MMO Reference: DCO/2022/00001  
Planning Inspectorate Reference: EN010121  
Identification Number: 20049449

## **Planning Act 2008, Floatation Energy, Proposed Morecambe Offshore Windfarm Generation Assets**

### **Deadline 2 Submission**

Plate 3.1 Flowchart diagram showing the mitigation process prior to piling *(based on current Project design)*

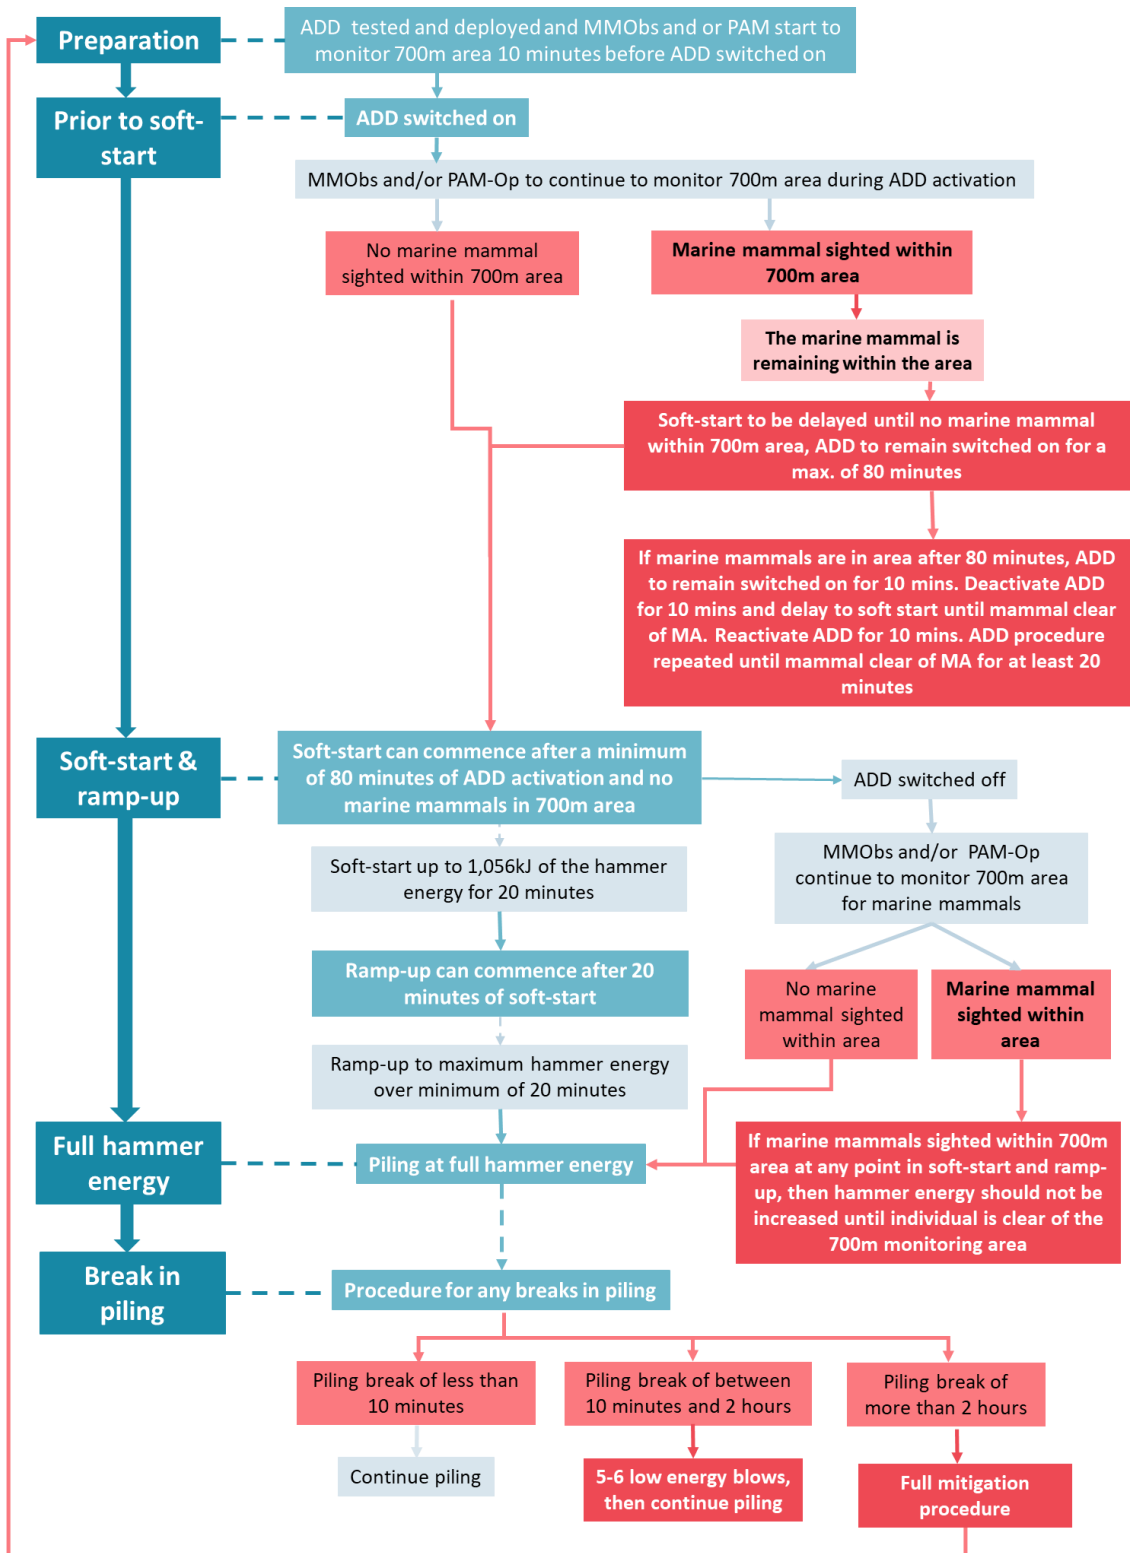
RR-047-27	<p>Further, Section 3.1.4 paragraph 143 regarding breaks in piling states</p> <p>"for any breaks in piling of less than 10 minutes, piling may continue as required (i.e. as if there was no break). For any breaks in piling of more than 10 minutes, but less than two hours, then the piling can recommence with a reduced soft-start procedure (e.g. five to six blows of the hammer at the starting hammer energy) before continuing as required, provided there are no marine mammals within the Management Area".</p> <p>The JNCC (2010) guidance recommends that if there is a pause in piling operations for a period of greater than 10 minutes, then the pre-piling search and soft-start procedure should be repeated before piling recommences. If a watch has been kept during the piling operation, the Marine Mammal Observer or Passive Acoustic Monitoring Operative should be able to confirm the presence or absence of marine mammals, and it may be possible to commence the soft-start immediately. However, if there has been</p>	<p>The Applicant acknowledges the request, however notes that the wording proposed by the Applicant has previously been agreed for other offshore windfarm projects, including Dogger Bank A and Dogger Bank B.</p> <p>The Applicant notes finalisation of wording in the Marine Mammal Mitigation Protocol (MMMP) would be undertaken post-consent alongside developed Project design information, in the event that piled foundations are selected as part of detailed design for the Project.</p>	<p>The MMO acknowledges that the final wording in the MMMP would be undertaken post-consent.</p> <p>The MMO alongside Cefas will be happy to review the finalised MMMP to ensure potential impacts are appropriately mitigated.</p> <p>The MMO will provide further comment at Deadline 3.</p>

no watch, the complete pre-piling search and soft-start procedure should be undertaken. The guidance recommends that the soft-start duration should be a period of not less than 20 minutes. Any requested variation from a 20-minute soft-start should be agreed with the relevant agency and regulator. The MMO and Cefas request that the guidance is adhered to, and the full soft start is implemented (not 5 to 6 blows at the starting hammer energy as is proposed in the MMMP).		
RR-047-28	Table 3.1 in the MMMP presents cumulative sound exposure Level (SELcum) modelled impact ranges for piling of both monopile and pin-pile at the worst- case (south west) location. The MMMP refers the reader to Appendix 11.1 of the ES (Document Reference 5.2.11.1) for more details, which describes the underwater modelling undertaken. Please note that the impact ranges presented in Table 3.1 are vastly different to those presented in Appendix 11.1 (see Table 4-22 in Appendix 11.1 for example which presents the impact ranges for monopiles and Annex 7.1 and 7.2 of this document). These discrepancies must be checked and clarified.	Table 3.1 in the draft MMMP (APP-149) lists the worst-case impact ranges for the Project based on the maximum strike rate scenario listed in Appendix B of Appendix 11.1 Underwater Noise Assessment (APP-065) and would be the worst-case impact range to be mitigated. There is no discrepancy, but it is noted that Appendix 11.1 Underwater Noise Assessment (APP-065) also presents the lower strike rate scenario.	<p>The MMO and Cefas previously noted that the predicted ranges in Table 3.1 of the MMMP are vastly different to those presented in Appendix 11. The MMO and Cefas recommended that these discrepancies should be checked and clarified.</p> <p>The Applicant has clarified with the MMO that additional modelling was completed for a higher strike rate.</p> <p>The MMO welcomes this clarification.</p> <p><a href="#">The MMO requests that this is made clear in an updated version of the Draft MMMP and will review the updated version of the document when submitted by the Applicant.</a></p>
